Historic England

14 September 2020

**Arrangements for Handling Heritage Application Direction 2015
& T&CP (Development Management Procedure) (England) Order 2015
& Planning (Listed Buildings & Conservation Areas) Regulations 1990**

**FORMER KIRKLEES COLLEGE, NEW NORTH ROAD, HUDDERSFIELD, HD1 5NN
Application Nos. 2018/92687 & 2018/92647**

This drawing shows an indicative design only.
Detailed planning permission is not sought for this building

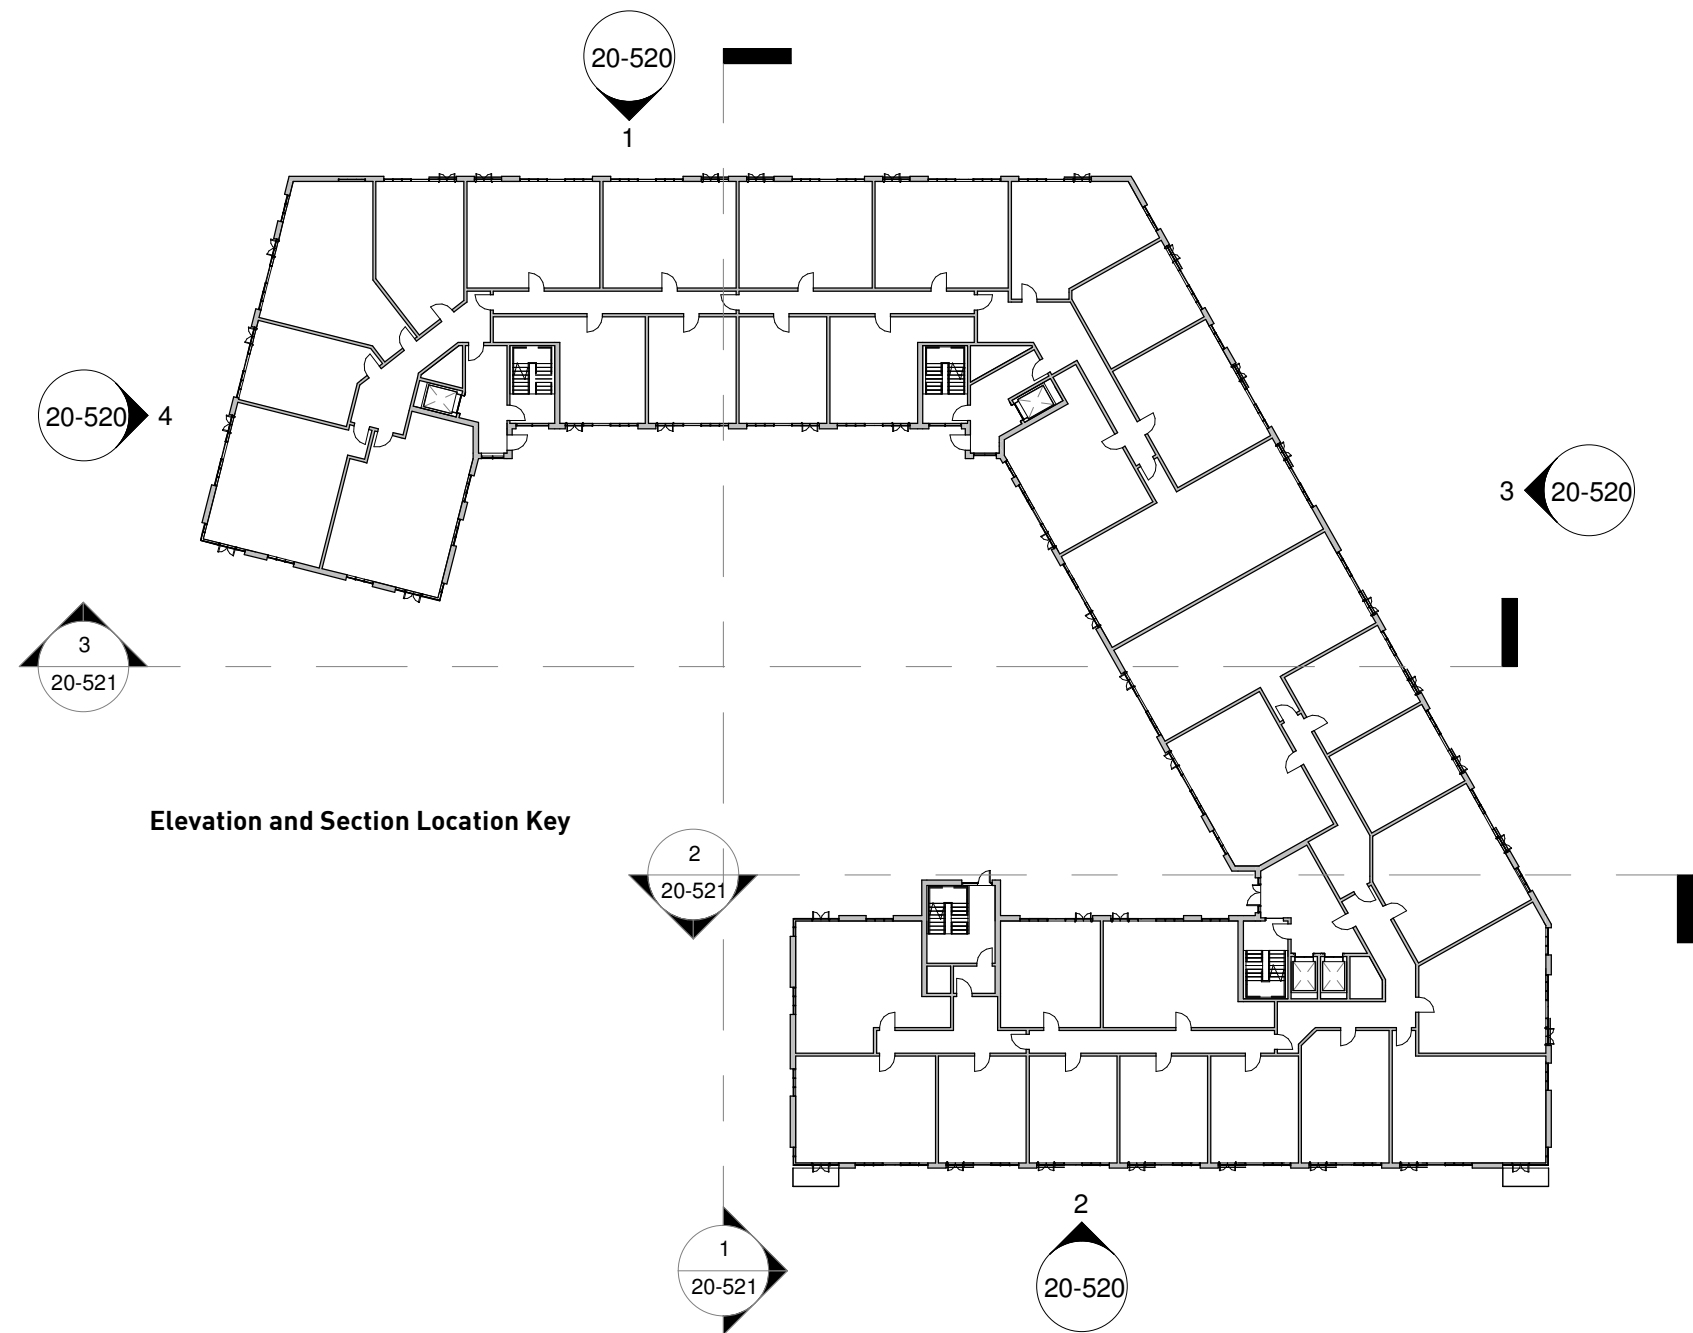
Although the layout of the proposed buildings (nos. 4 and 5) seeks precedent on the historic grain, the footprint, massing, scale and detailing of the proposed development are not sympathetic to this historic context. The concern is that the number of units and the proposed block arrangement is likely to result in a significant mass and scale, which will be overly dominant in this context; this would have a detrimental impact on to the setting of the grade II* Infirmary, the grade II listed church and surrounding listed buildings and the character of the area. While providing a means of reducing surface parking, the incorporation of a undercroft parking, with its consequent inactive frontage at street level, is likely to compound the negative effects on the immediate context.
